Rezoning Transportation Analysis

Petition Number: 2023-022

General Location Identifier: 02954104

Date	Description
06-28-23	First Review (TM)
07-26-23	Second Review (TM)
08-29-23	Third Review (ME)

SCHEMATIC SITE PLAN

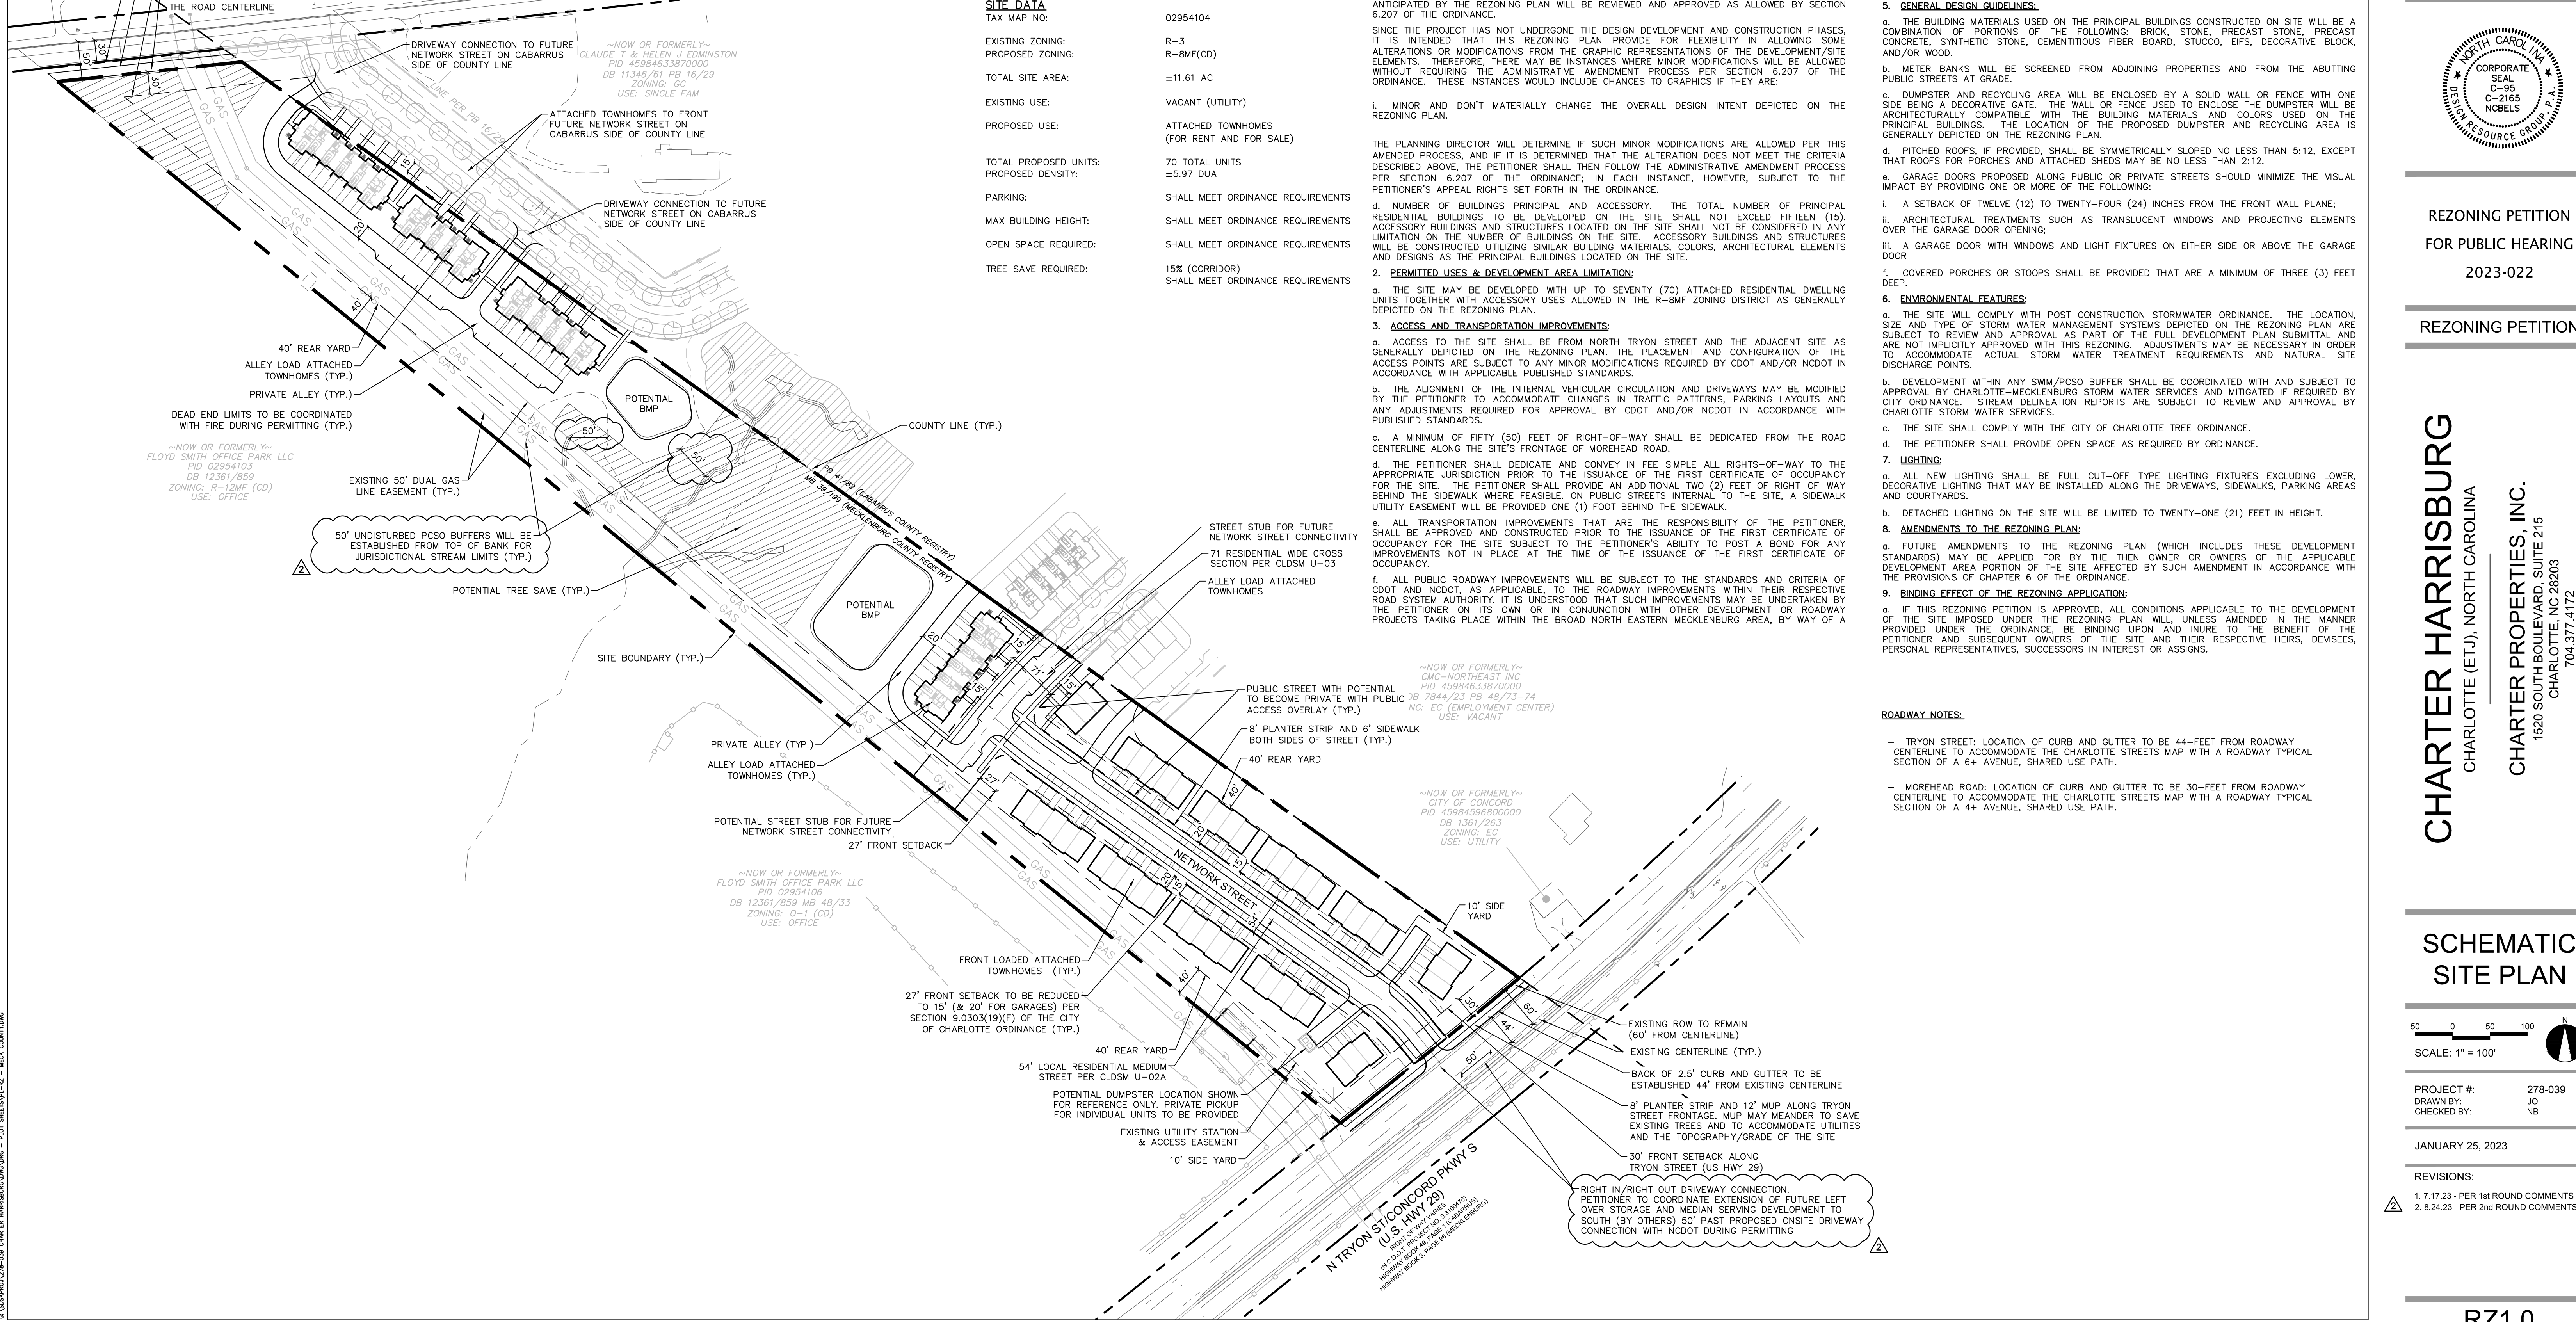
6. Revise site plan and conditional note(s) to commit to removing the Tryon Street Access point in coordination with NCDOT. Site shall utilize the internal street network within the adjacent development.
